**KIRKLEES METROPOLITAN COUNCIL
INVESTMENT & REGENERATION SERVICE**

**DELEGATED DECISION FOR APPLICATION FOR CERTIFICATE OF
LAWFUL DEVELOPMENT**

Reference no.: 2025/CL/92207/E

Site: Copley House Farm, Hunsworth Lane, East
Bierley, BD4 6RN

Client:	Date:	Scale:
Mr Massey	July	1:100 @A3
Project Name:	Drawn:	Reviewed:
Copley Farm	OS	EP
Drawing Title:	Drawing No:	Revision:
Proposed Elevations	007	B
Drawing Status:	Project No:	
Planning	2024.06

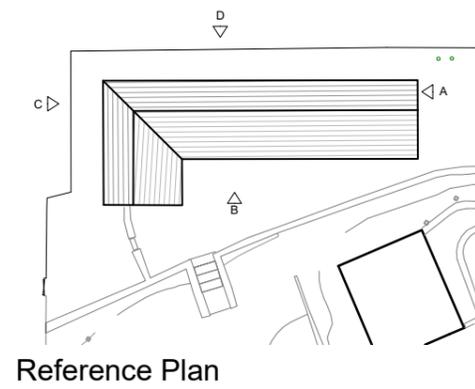
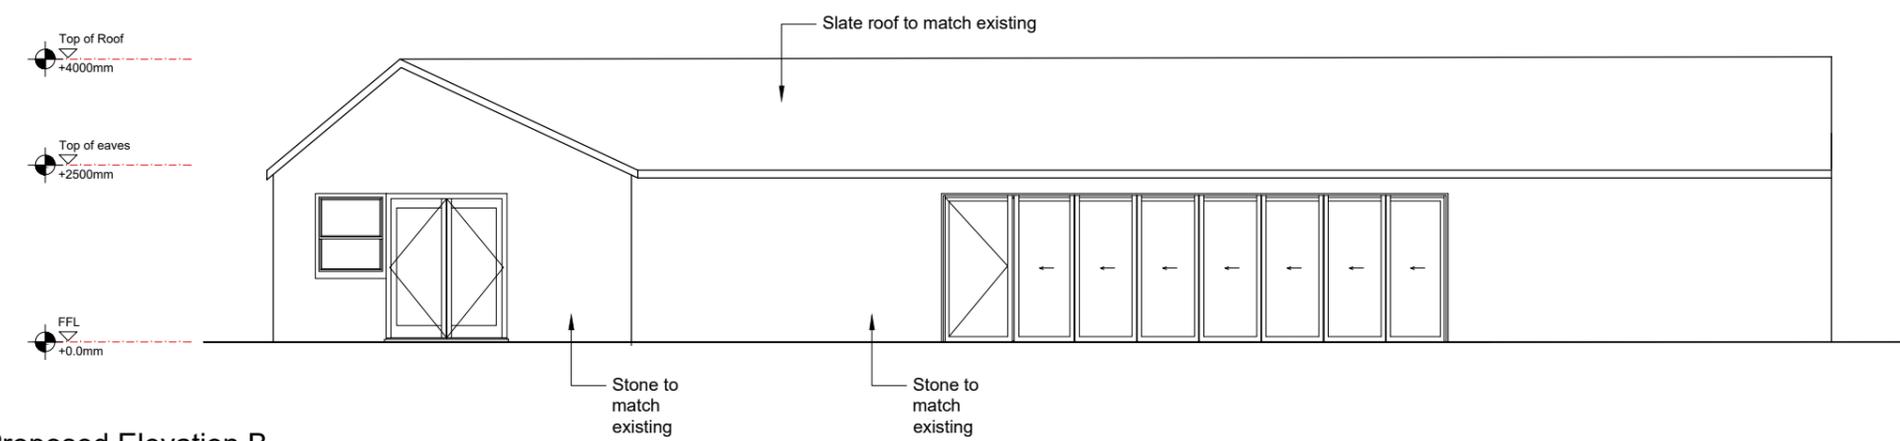
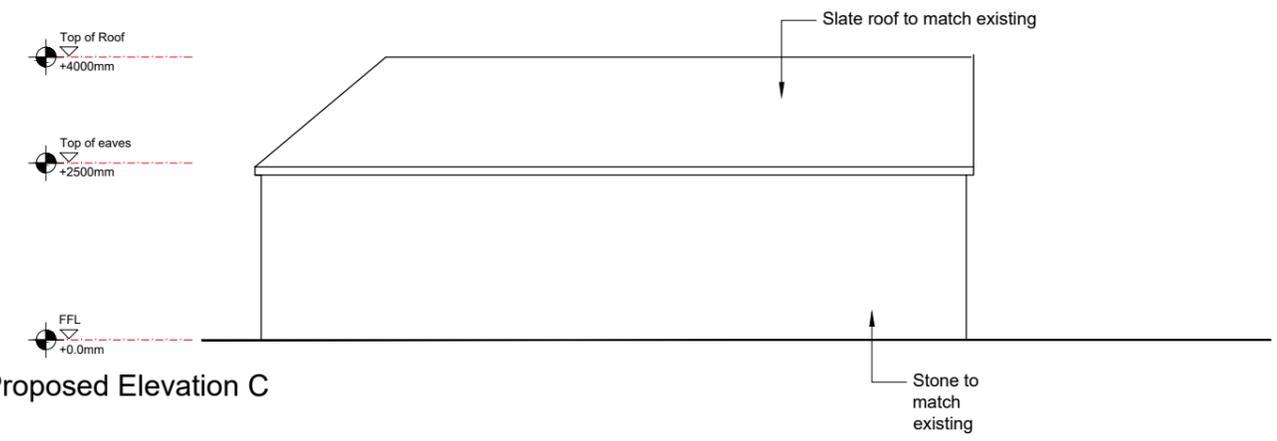
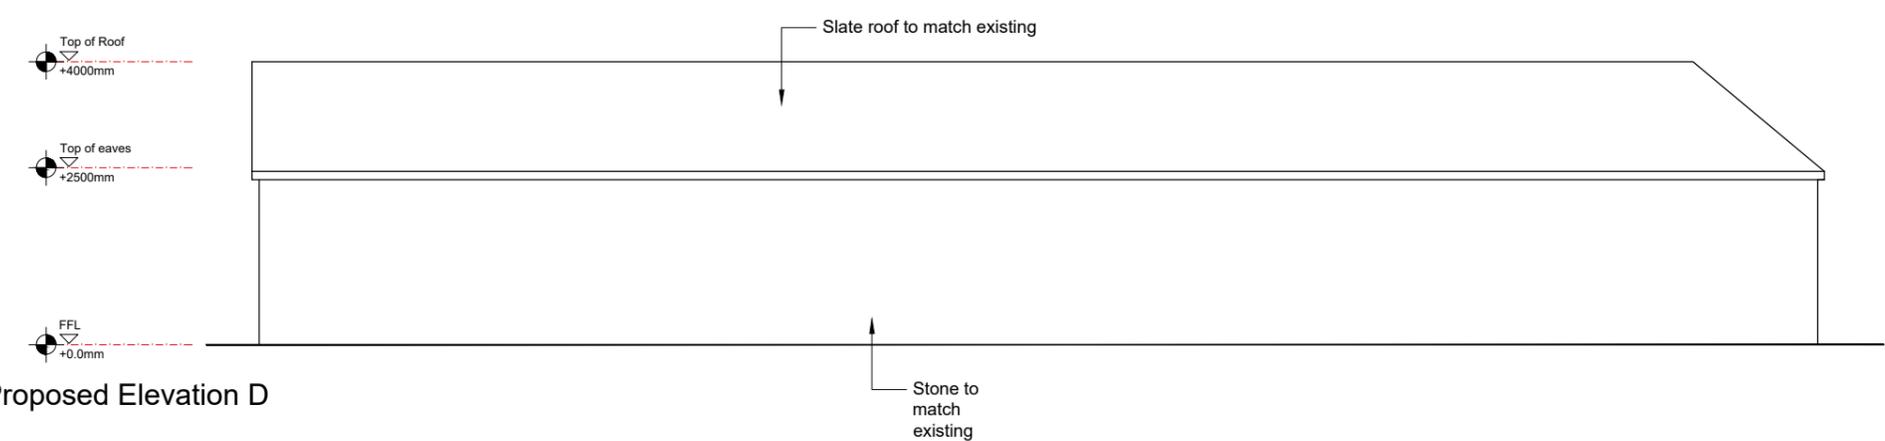
The outbuilding is 'L' shaped in its design and would have a length of 22 metres, maximum depth of 10 metres with an eaves height of 2.5 metres and overall height of 4 metres with a dual pitched roof. The proposed accommodation would be storage, a cinema room with drinks and snack bar, home office and a gym.

Comment: *The outbuilding is not located within 2 metres of a boundary and does not exceed 4 metres in height to the ridge of the dual-pitched roof.*

Comment: *The height of the eaves of the building would not exceed 2.5 metres.*

Client:	Date:	Scale:
Mr Massey	July	1:100 @A3
Project Name:	Drawn:	Reviewed:
Copley Farm	OS	EP
Drawing Title:	Drawing No:	Revision:
Proposed Ground Floor Plan	006	F
Drawing Status:	Project No:	
Planning	2024.06

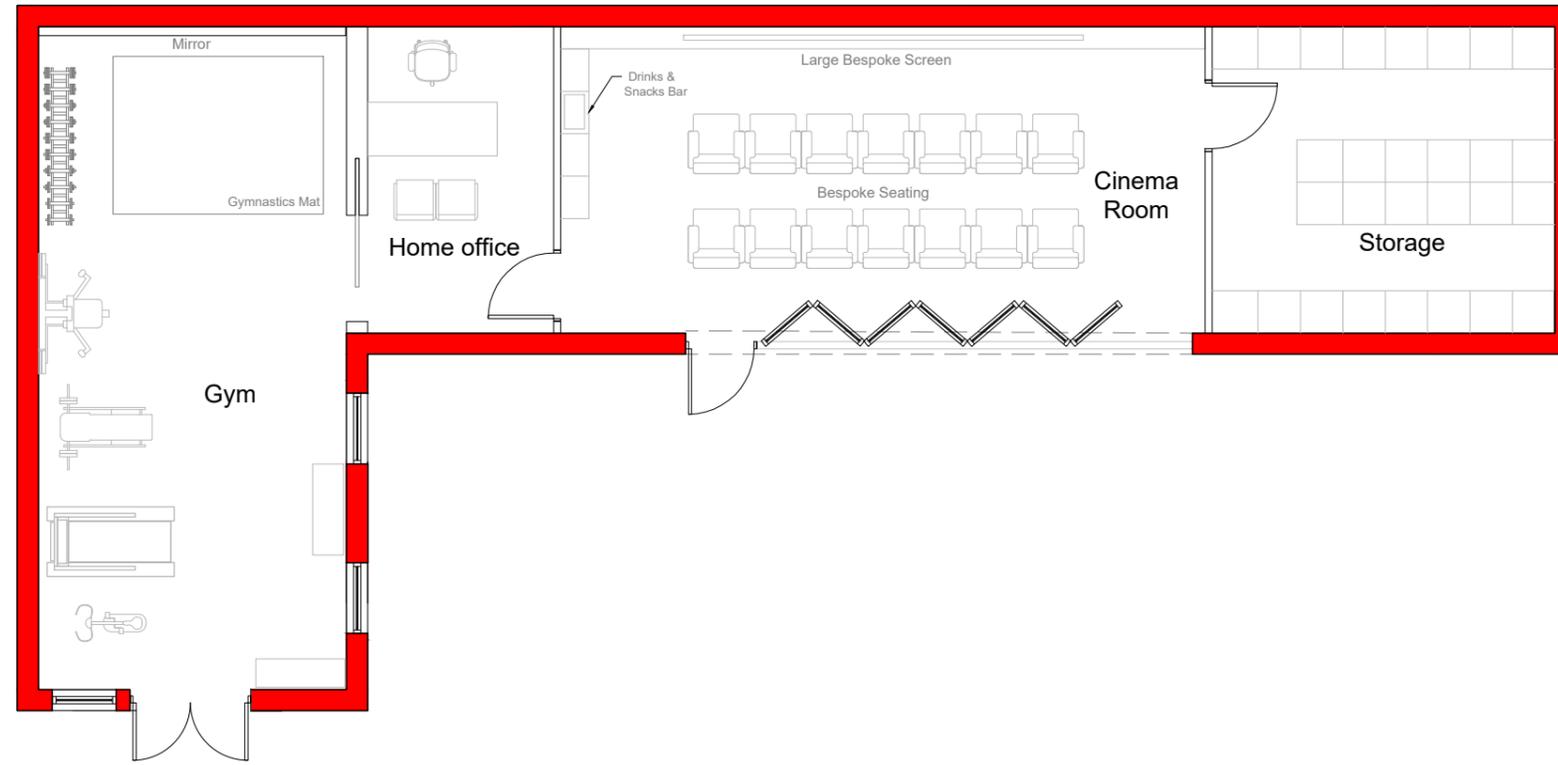
The submitted plans indicate that the use of the gym would be approximately 40 square metres, the home office would be approximately 11 square metres,

the cinema room approximately 40 square metres and the storage area approximately 20 square metres.

While the submitted plans indicates 14 seats in the cinema room, the covering letter states that the cinema room offers 9 seats in total with the host building containing 5 bedrooms, at least of 3 of which has doubles and therefore has the capacity for at least 8 people with the amount of seating included in the room equating to 1 seat per site occupant. The applicant also points to an appeal decision¹ whereby an inspector commented that a TV/cinema room would normally be accommodation expect to be in the main dwellinghouse but inferred a custom-built film screening area may not. The applicant argues the cinema room is custom built but provide no reasoned justification by other than to suggest the layout demonstrate this.

In a similar appeal decision² an inspector commented that a cinema room containing seating and a large screen intended for entertaining, relaxation, socialising and watching films or television would not normally require accommodation separate to the living space contained within the main dwellinghouse. In this instance, with reference to the applicant's cover letter, it specifically states the cinema room is to be used by the family the for entertainment purposes being uses precisely considered by both inspectors to be accommodation normally found in the main dwellinghouse. The applicant has not shown that the cinema room is genuinely required as an area designed or custom built, for example as an area to accommodate a film viewing hobby, as a film critic or other area whereby viewing films would not be an activity one may need a separate space other than a living room. Consequently, there is little distinction between a cinema room and a living room with a TV and seating and therefore must be considered a primary living area and as such, not

incidental to the enjoyment of the dwellinghouse but rather an extension of normal living areas.

Whilst it is accepted that a home gym in principle could be incidental, the applicant has not provided specific training need to clearly identify the purpose and incidental quality of the range of equipment that is genuinely and reasonably required to justify the space to accommodate this equipment. If appears the only reasoned justification for the floor space of the proposed outbuilding is that conversion of the existing stable is not possible and a replacement building on the same footprint is the preferred option.

Overall and while the use as a home office alone maybe considered incidental, all the uses within the proposed outbuilding would need to be incidental to benefit from any permitted development rights under Class E. In this instance, it has not been demonstrated that all the uses within the proposed large outbuilding are reasonably required for purposes incidental to the enjoyment of the dwellinghouse.
